August 5, 2005

RE: Application for Single Family House, Ball Park Drive, Lot 2, ID # 2005-0170

Upon review of the site plan, the City's Planning Division has the following comments:

SITE PLAN
OF
LOT 2 BALLPARK DRIVE, PORTLAND, MAINE
MADE FOR
ANTHONY ORLANDO
57 SHEPHERD LANE, PORTLAND, MAINE

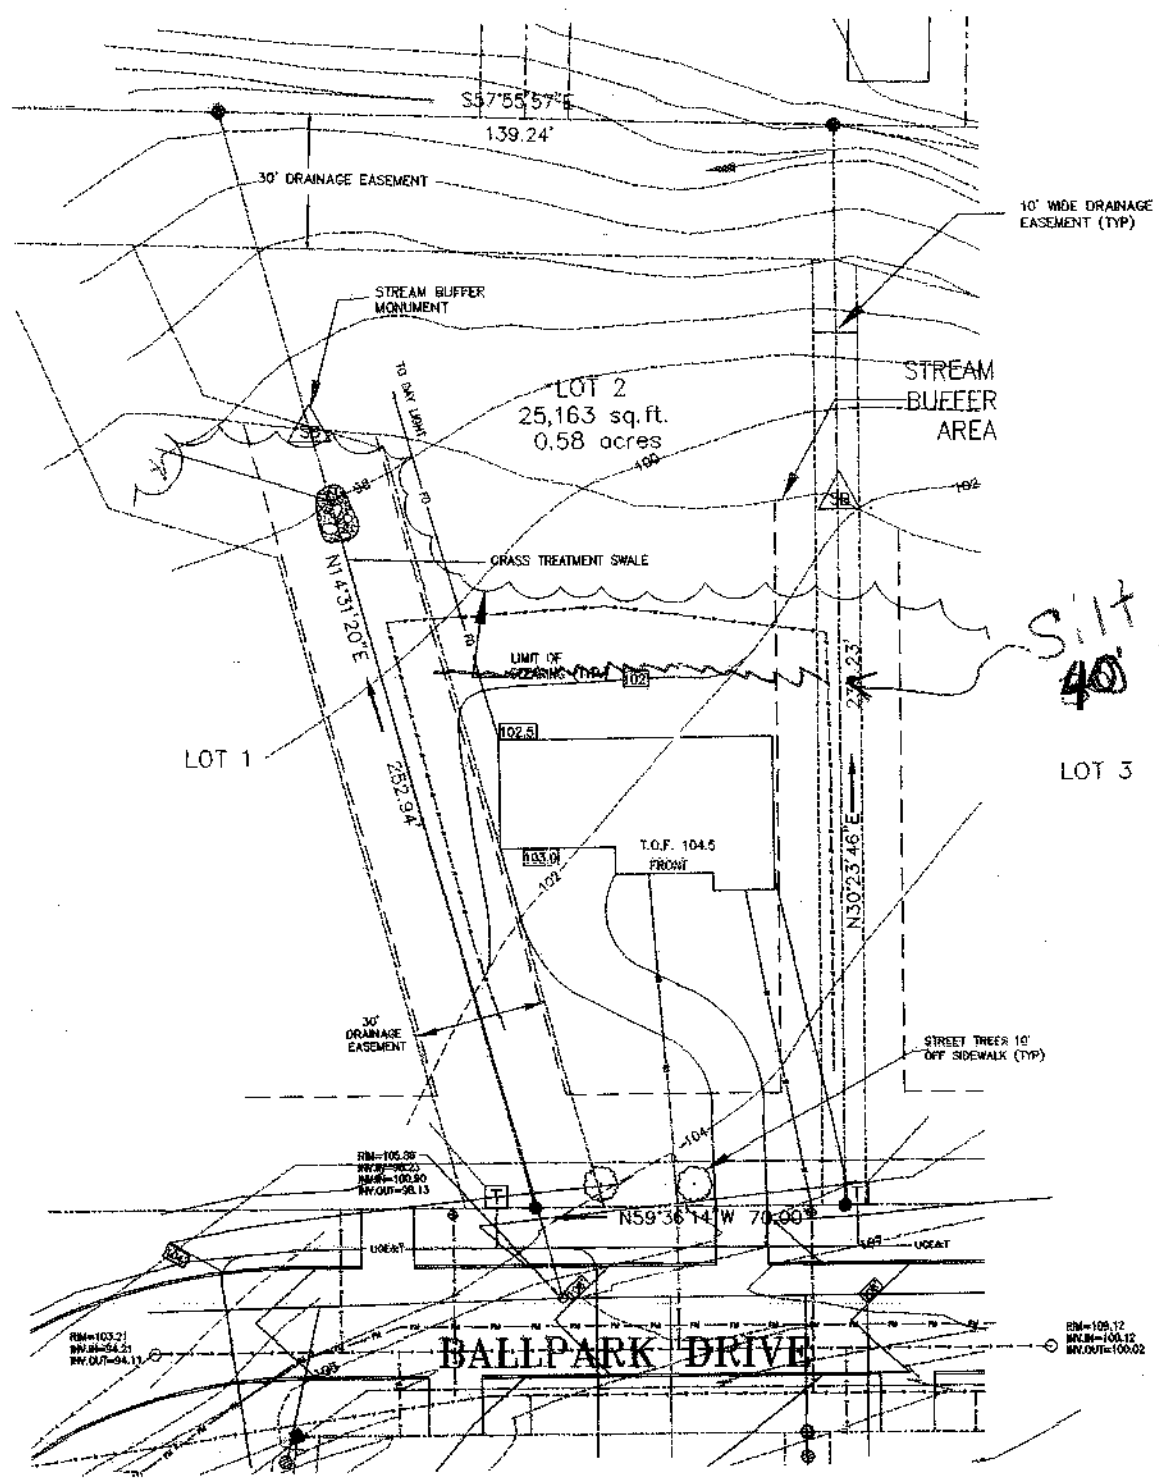
1. There is a 10' easement on your site plan that was not part of the Ball Park Subdivision. Please elaborate.
2. Please remove the foundation drain that falls within the stream buffer limit.
3. A sewer cleanout is required on sewer services greater than 80 feet from the sewer main. Please add a cleanout to the plan.
4. Reduced size/copy of site plan was not to-scale.
